DRB Project Number: 104480
47th & Glendale

SUBJECT: Preliminary/ Final Plat

Project #: 1004480

Application #: 18DRB-70044

**PLAT OF  
 LOT A  
 LANDS OF ROGELIO SOLIS**

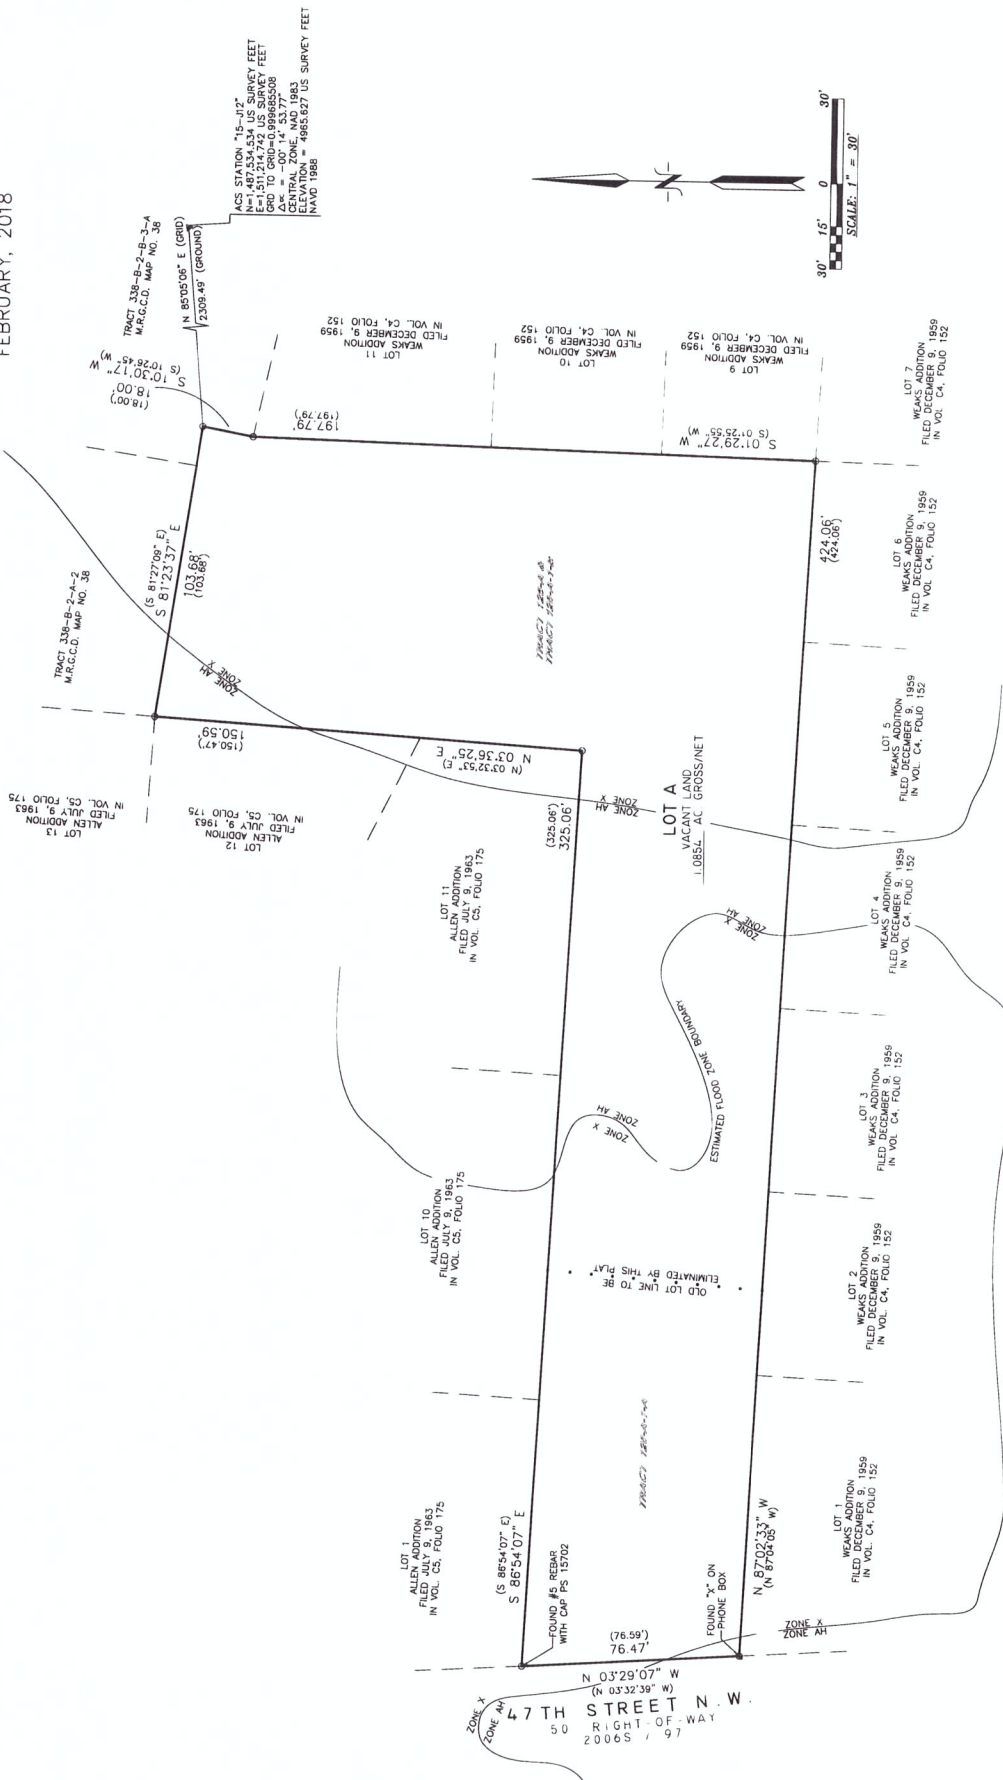
- Add a signature line for Code Enforcement
- Fill in the project number and application number on the plat
- This site falls outside the West Mesa SDP boundary. It is not within a SDP
